# Norfolk Boreas Offshore Wind Farm Joint Position Statement with North Norfolk District Council Noise Sensitive Receptors

Applicant: Norfolk Boreas Limited  
Document Reference: ExA.AS-5.D6.V1  
Deadline 6

Date: March 2020  
Revision: Version 1  
Author: Royal HaskoningDHV

Title:
Noise receptor locations
(Map 1 of 9)

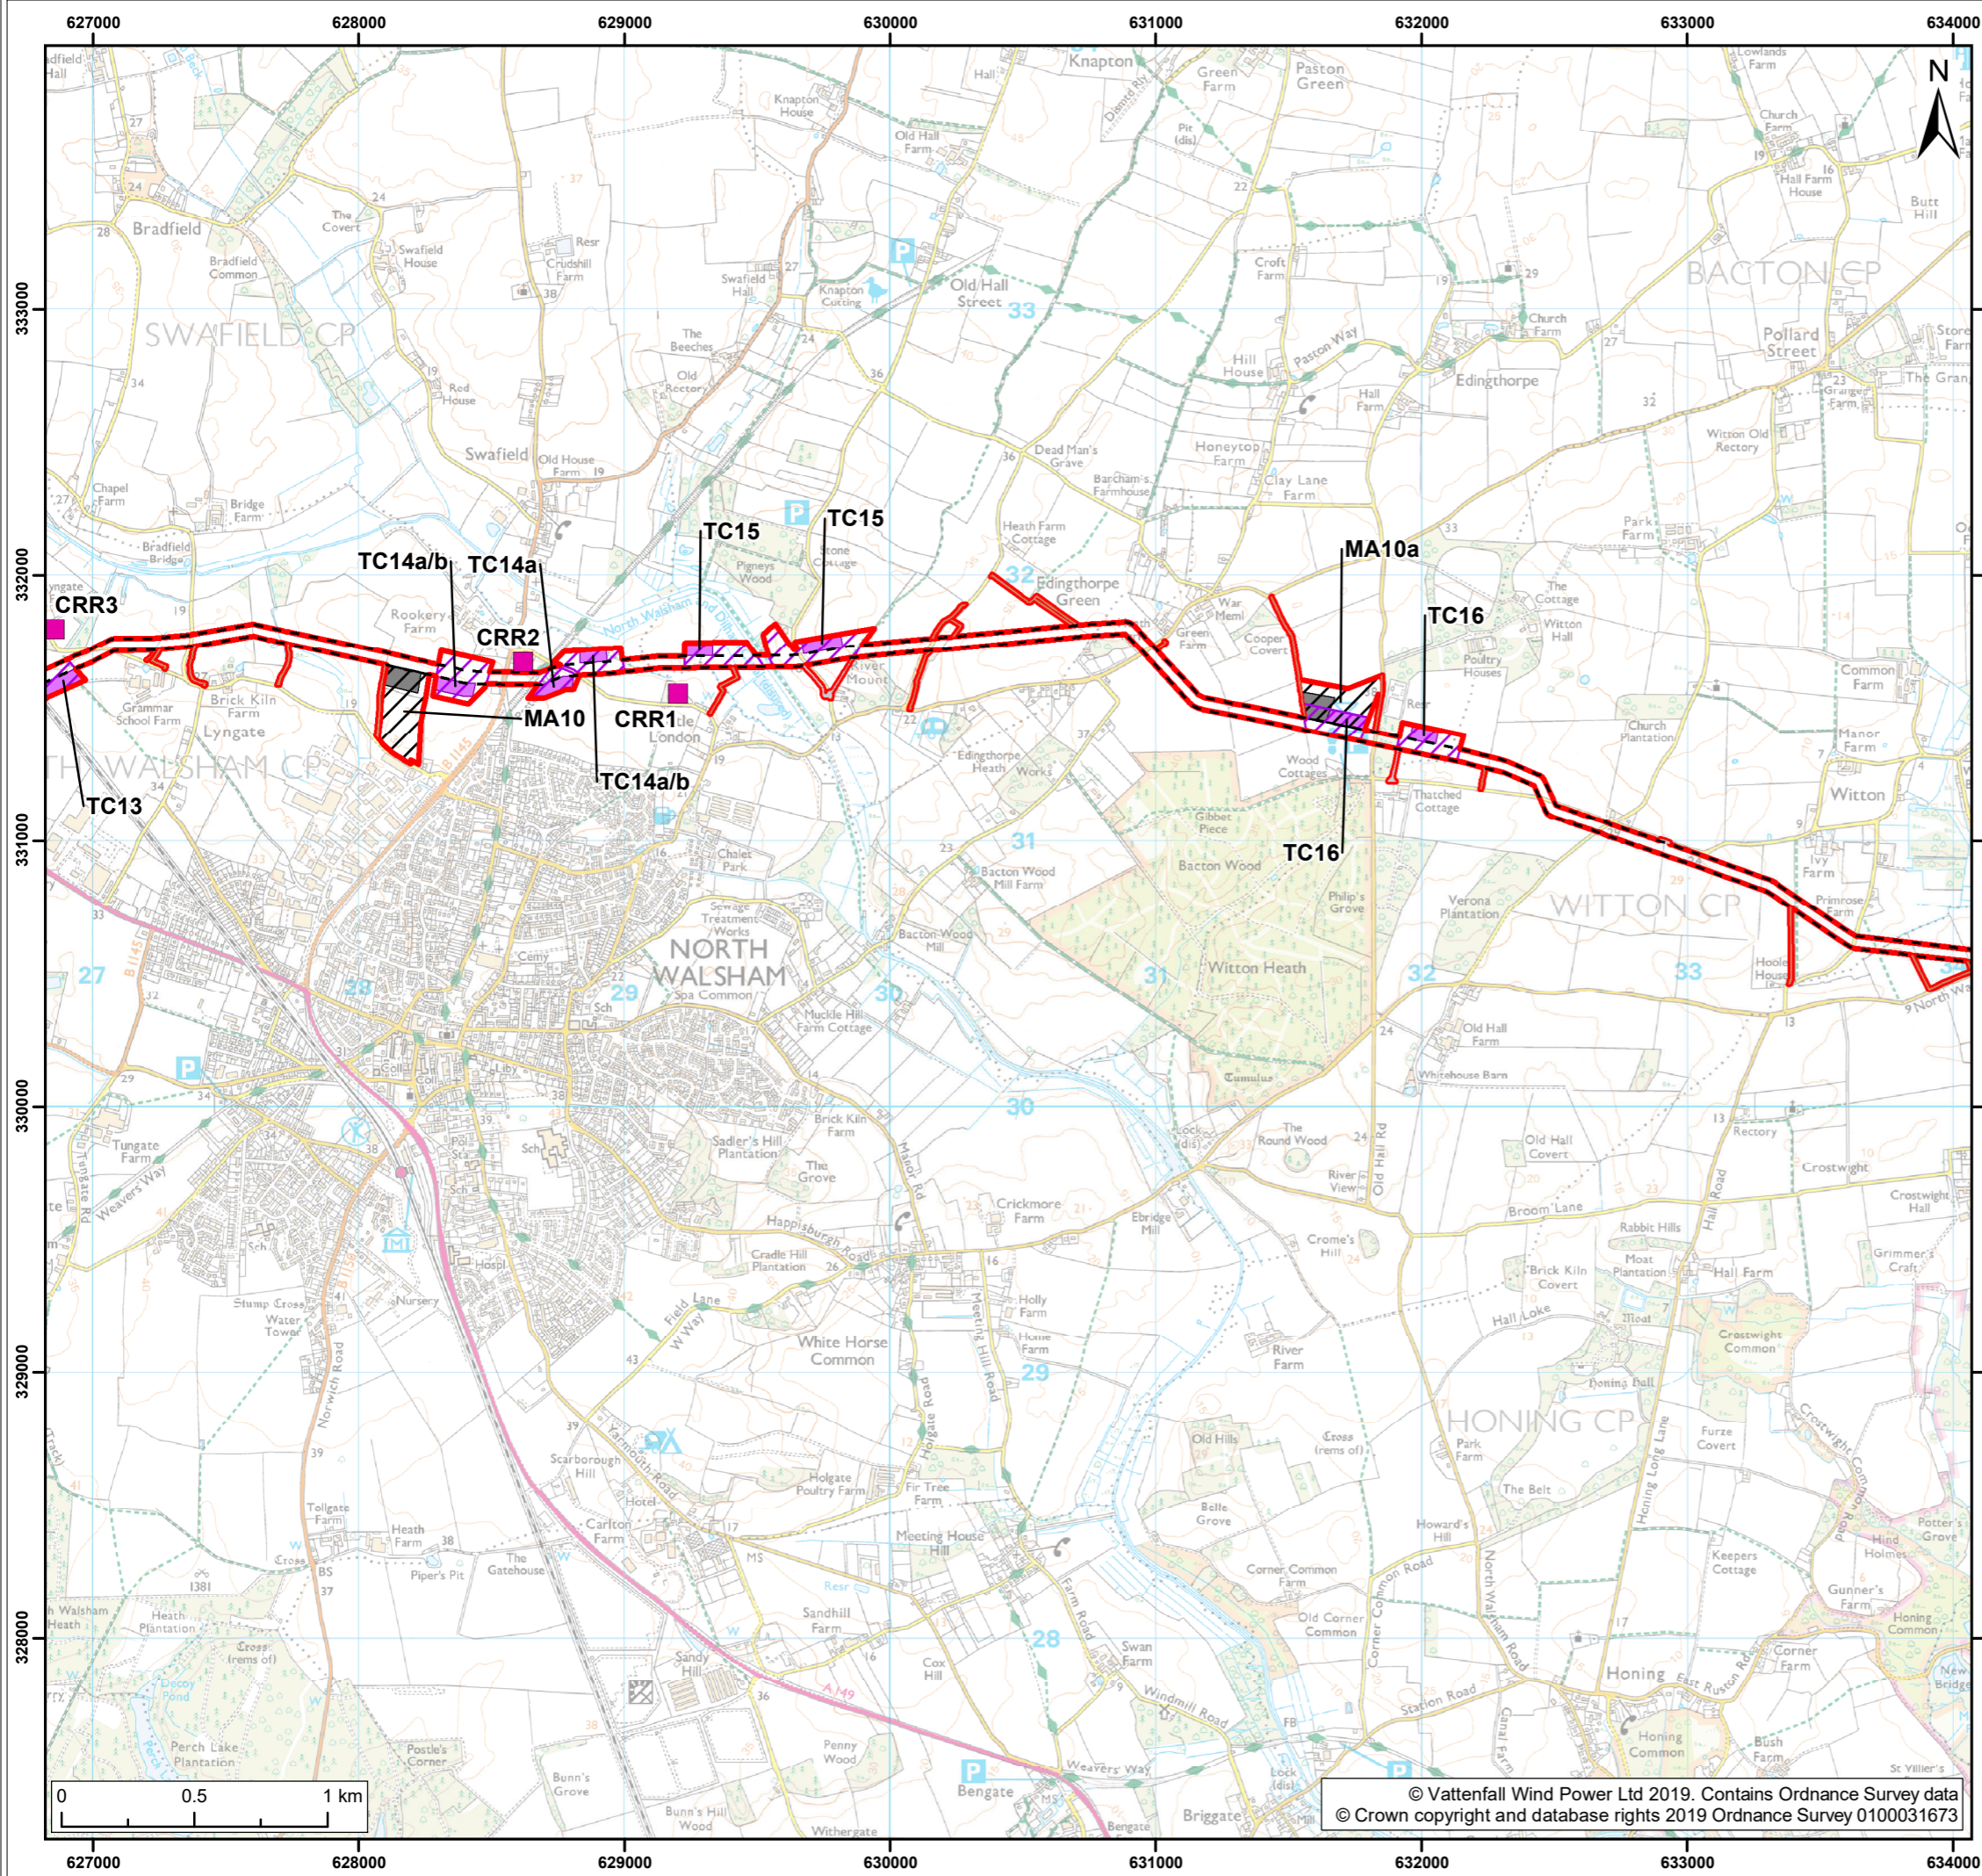
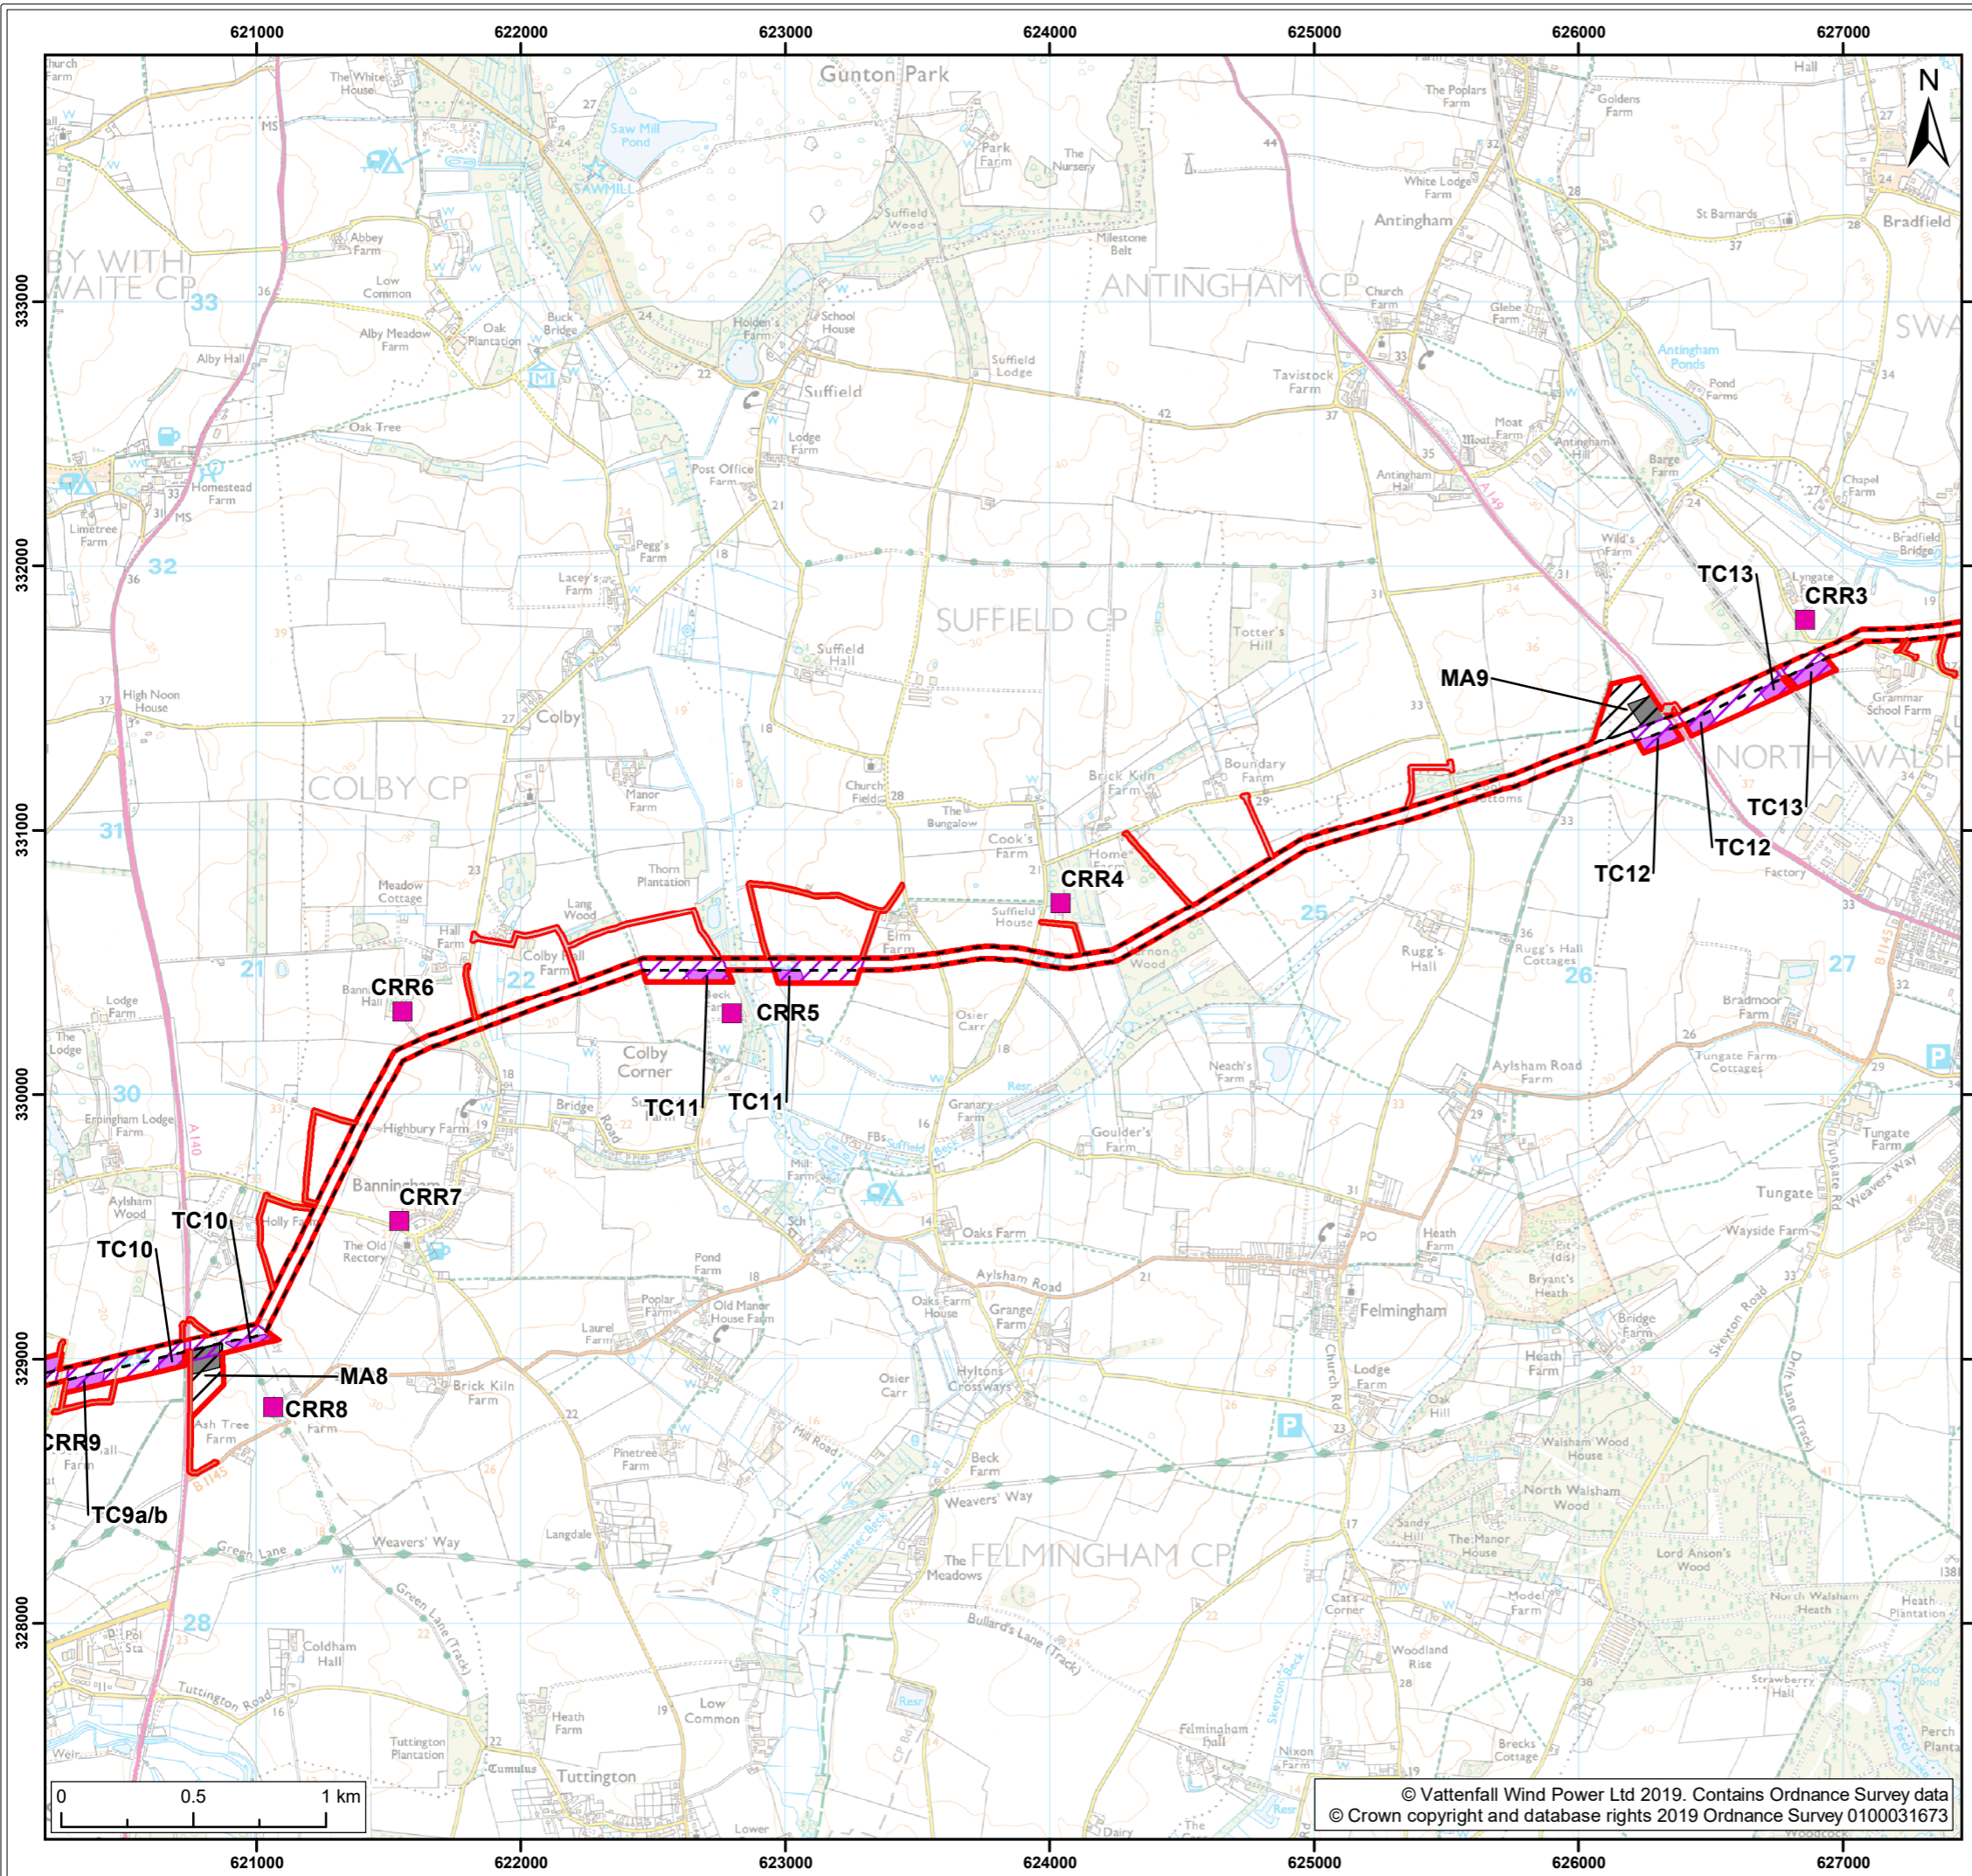
21. In terms of the locations set out above at paragraph 14 a) and b), whilst NNDC note these examples, the locations of which are set out in document 6.2.25.2 Environmental Statement - Figure 25.2 Noise Receptor Locations [APP-470], it would be helpful and clearer to all parties if these locations are also described by their address location (e.g. road name and village) and/or add map references.

- 3) In Table 1 Cycle routes to be identified as low sensitivity receptors rather than negligible.
  - 4) For the receptor locations identified as potentially requiring enhanced mitigation (in section 3.1) to also be described by their address location (e.g. road name and village) and/or add map references.

- ii. Provide additional detail on the receptor locations requiring enhanced mitigation to include road name and village and a map reference;
  - iii. Include additional text (as per Section 3.2) to confirm that the development of the CNMP will include a review of the construction activities and the identification of any potential noise sensitive receptors (as defined in Table 1) which may be affected and identify any potential control to minimise effects.
